KIRKLEES METROPOLITAN COUNCIL INVESTMENT & REGENERATION SERVICE

DELEGATED DECISION TO DETERMINE PLANNING APPLICATIONS

Reference No:	2025/62/90734/W
Site Address:	Whinney Dene, West Field Lane, Wooldale, Holmfirth, HD9 1RD
Description:	Demolition of existing stables building and erection of detached dwelling
Recommending Officer:	Danielle Cooper

DECISION – CONDITIONAL FULL PERMISSION

First floor layout

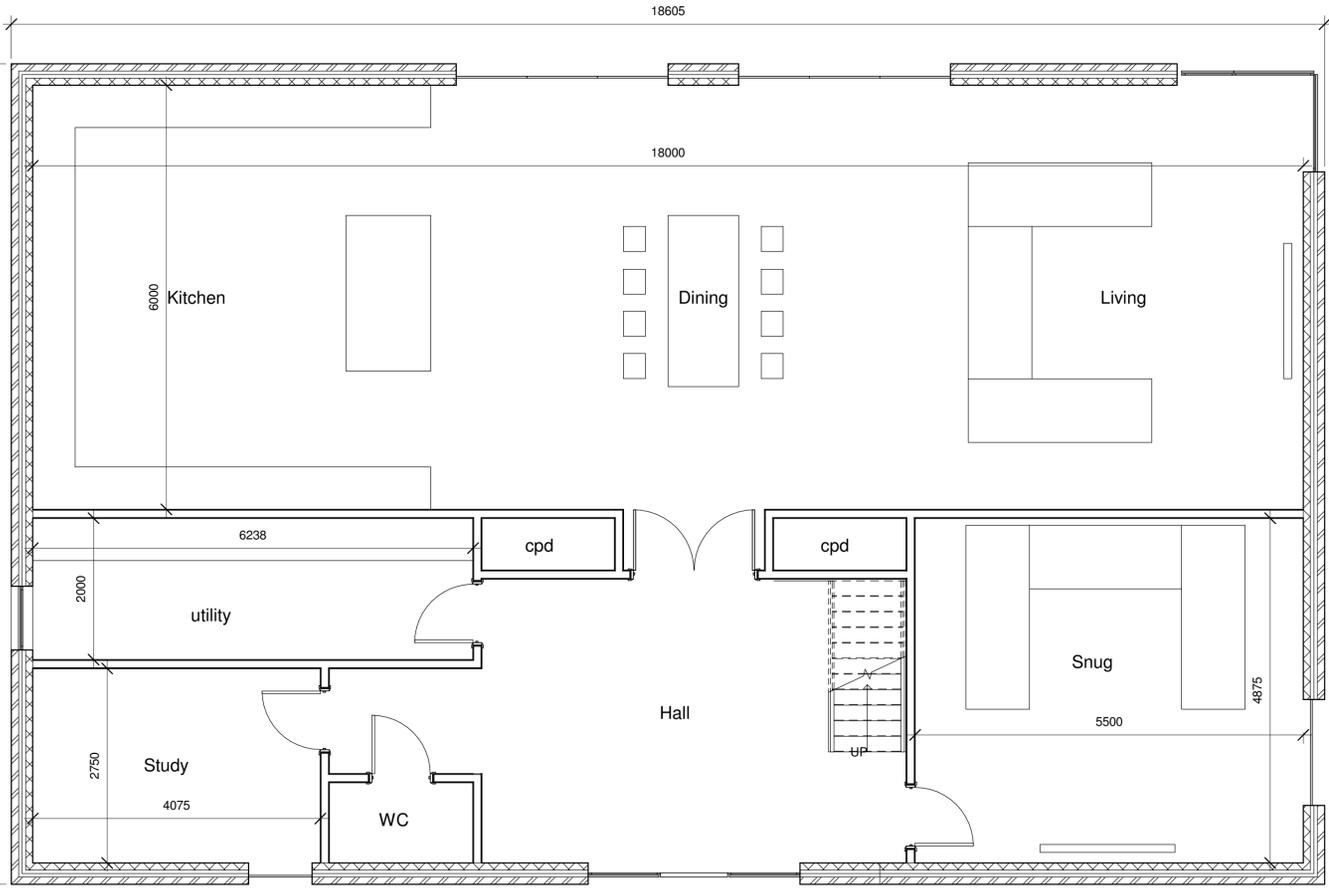
4. The development shall not be occupied until the first floor south side window of the hereby approved scheme has been obscurely glazed (to a minimum Grade 4). Notwithstanding the provisions of the Town and Country Planning (General Permitted Development) Order 2015 as amended (or any Order revoking or re-enacting that Order) the obscure glazing (to a Grade 4) shall thereafter be retained.

REVISION	DATE	DESCRIPTION
A	12/06/25	House redesigned

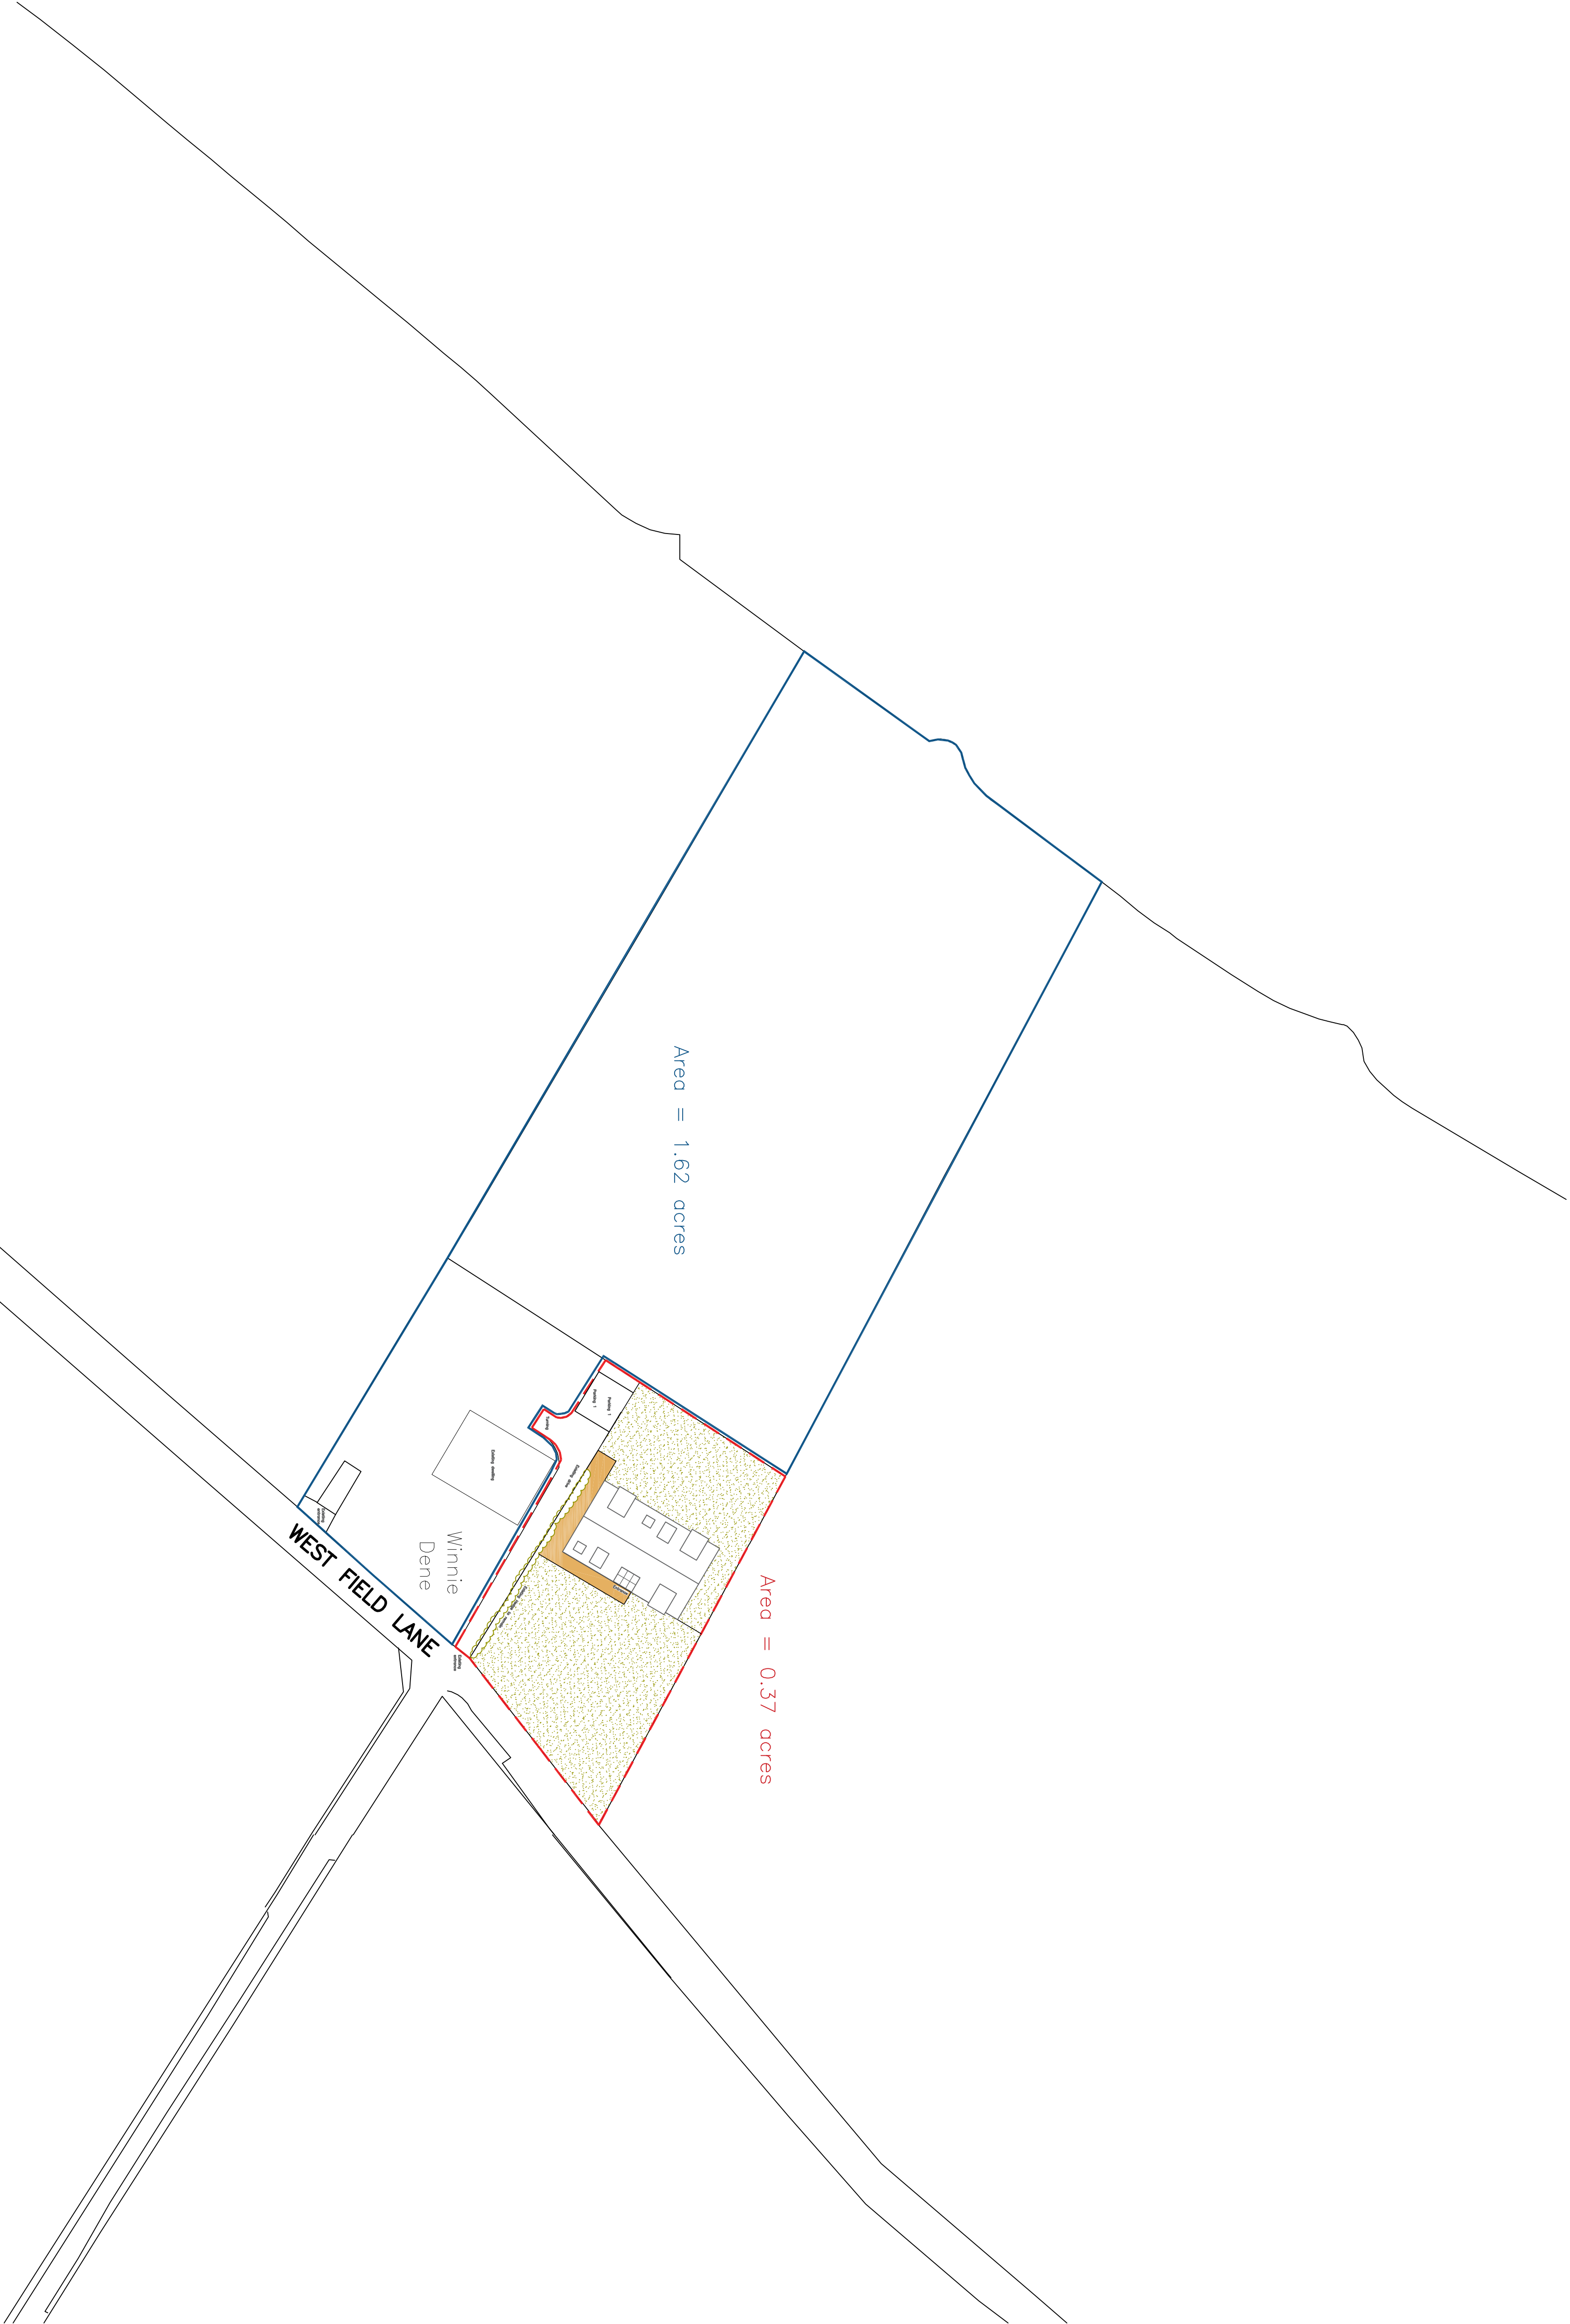
6. The dwelling hereby approved shall not be occupied until all areas indicated to be private drives on Drawing No. 2555-4A, received 18/06/2025, are laid out with a hardened and drained surface in accordance with the Communities and Local Government; and Environment Agency's 'Guidance on the permeable surfacing of front gardens (parking areas)' published 13th May 2009 as amended or any successor guidance. Notwithstanding the provisions of the Town and Country Planning (General Permitted Development) (England) Order 2015 as amended (or any Order revoking or re-enacting that Order) these areas shall be so retained, free of obstructions and available for parking thereafter.

8. The approved path as shown on the Drawing No. 2555-4A, received 18/06/2025, shall be fully laid out from loose limestone gravel. The path shall thereafter be retained.
